2 storey extension to provide sunroom/study, dressing room and en suite bathroom.
This application may affect the setting of a Listed Building.

26 Barrack Lane Aldwick

Thank you for your internet representation made on 6th October 2019 which has been recorded as '**an objection**' with the comments as follows:

SOUTH ELEVATION
WEST ELEVATION

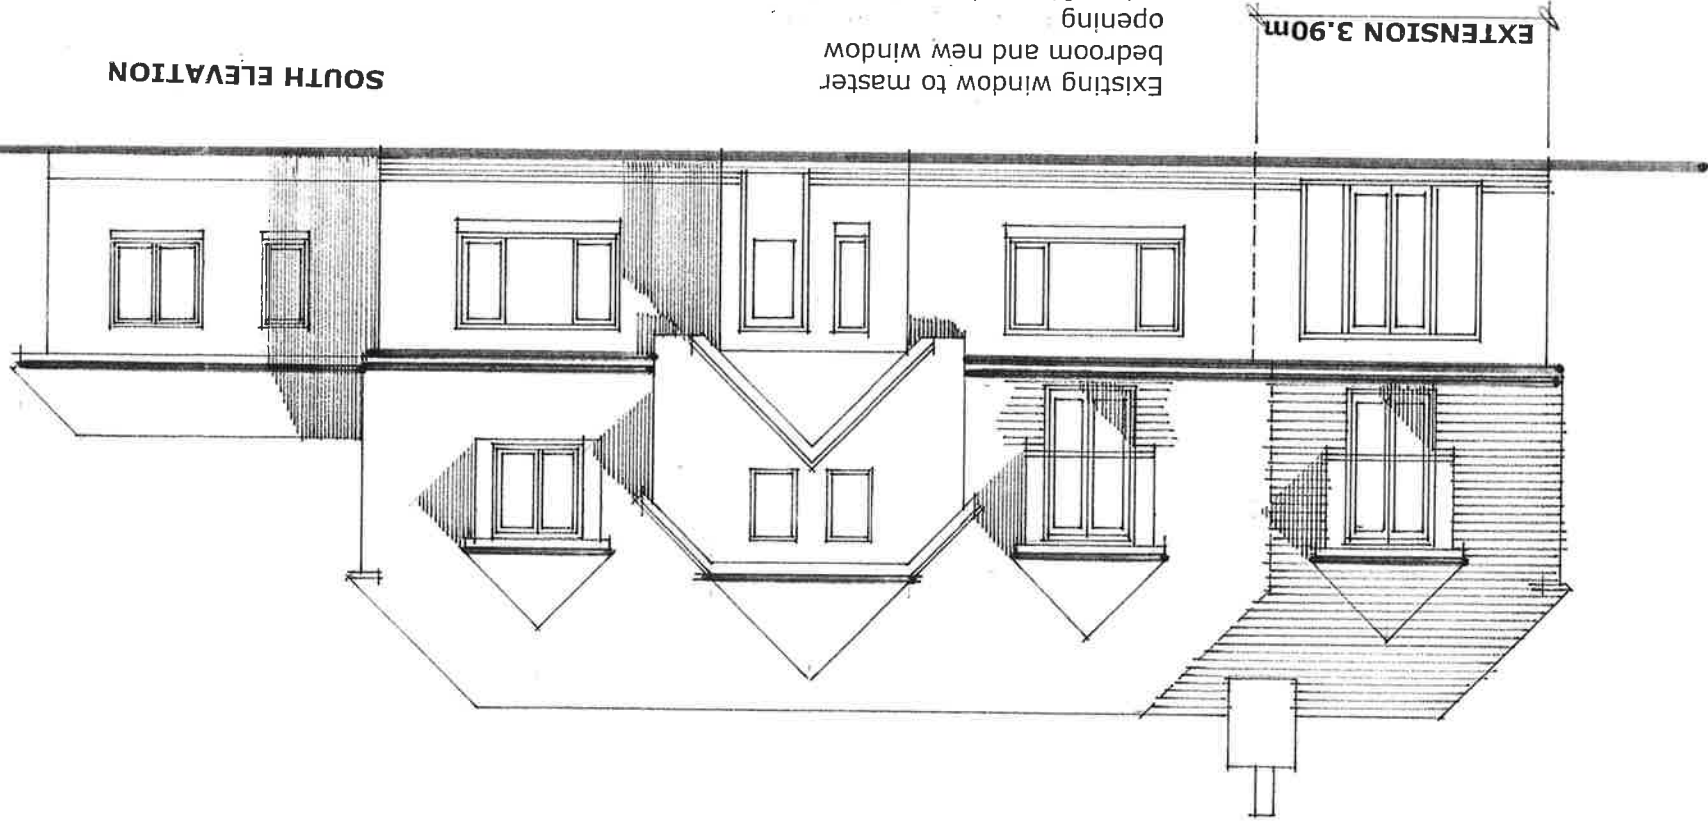
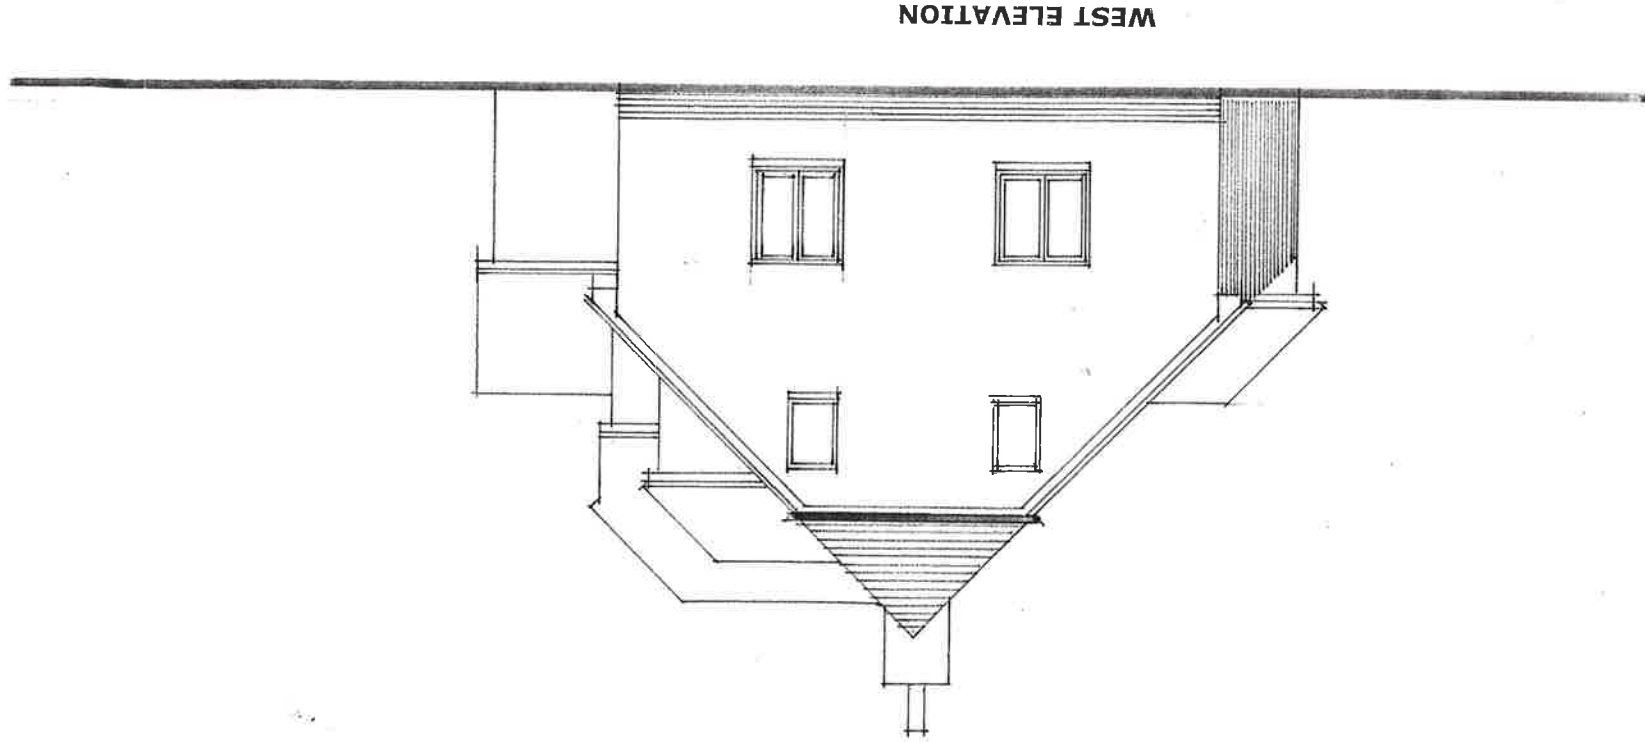
I am the co owner of 24 Barrack Lane, a property directly opposite the application site which is visible from our property. The proposed extension plans show 2nd floor rooms with windows facing out onto Barrack Lane. As our property is a single storey bungalow these windows will have a direct line of sight into our bedroom windows. Consequently, if Planning Approval is granted, I would like these windows to be fitted with obscured glass.
